Application for a non-material amendment following a grant of planning permission.

Unit:		House number:		House suffix:	
House name:	HAWTHORNE HOUSE				
Address 1:	RIBBLESDALE AVENUE				
Address 2:					
Address 3:					
Town:	CLITHEROE				
County:	LANCS				
Postcode (optional):	BB7 2HZ				
Description of location or a grid reference. (must be completed if postcode is not known):					
Easting:	374 148	Northings:	442 499		
Description: SELF BUILD RESIDENTIAL DWELLING.

PROPOSED ERECTION OF A DETACHED 2-STOREY DWELLING

3/2024/0303

Drawing Title
Existing and Proposed Site Sections and Garage Plans and Elevations.
Scale
1:50 @A1
Date
Drawn

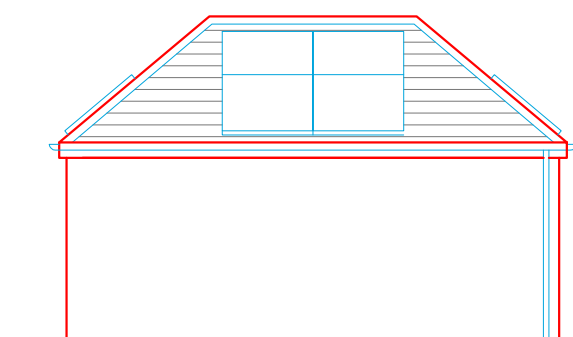
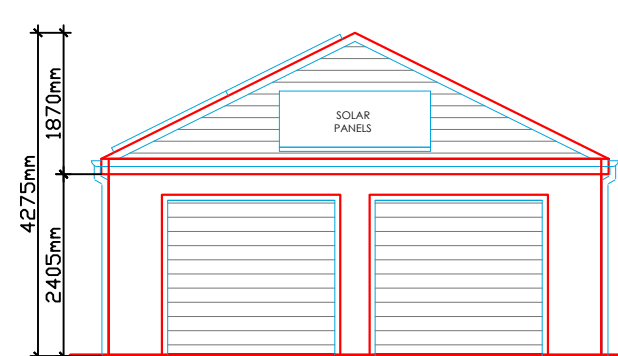
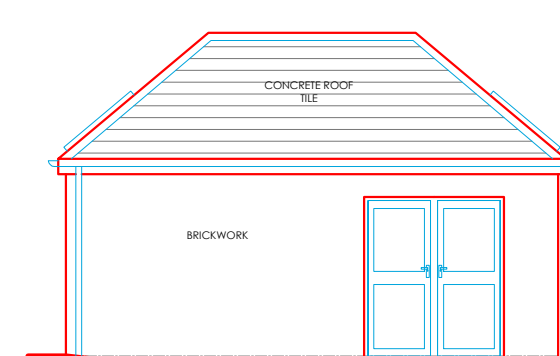
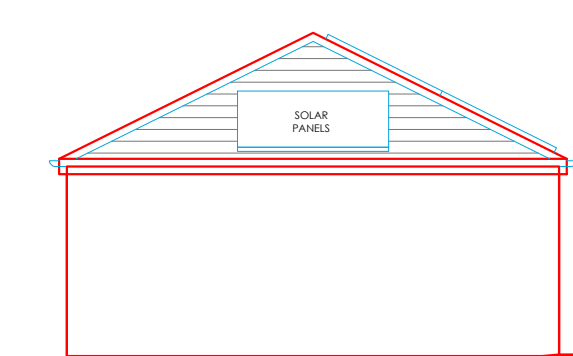
- 1) OMIT A NUMBER OF WINDOWS AS HIGHLIGHTED ON DRAWING 7027-P03F
- 2) AMEND PROPOSED BOUNDARY TREATMENT AS HIGHLIGHTED ON DRAWING 7027-P02F
- 3) DRAWING 7027-S02B WAS UPDATED BY THE ARCHITECT IN ERROR, THE HIGHWAY RESPONSE REQUIRED THE SET BACK & VISIBILITY SPLAYS TO BE UPDATED ON KNUNCK KNOWLES DRIVE. HOWEVER THEY ALSO ADDED ON RIBBESDALE IN ERROR. VISION SPLAYS ARE NOT REQUIRED FOR AN ENTRANCE
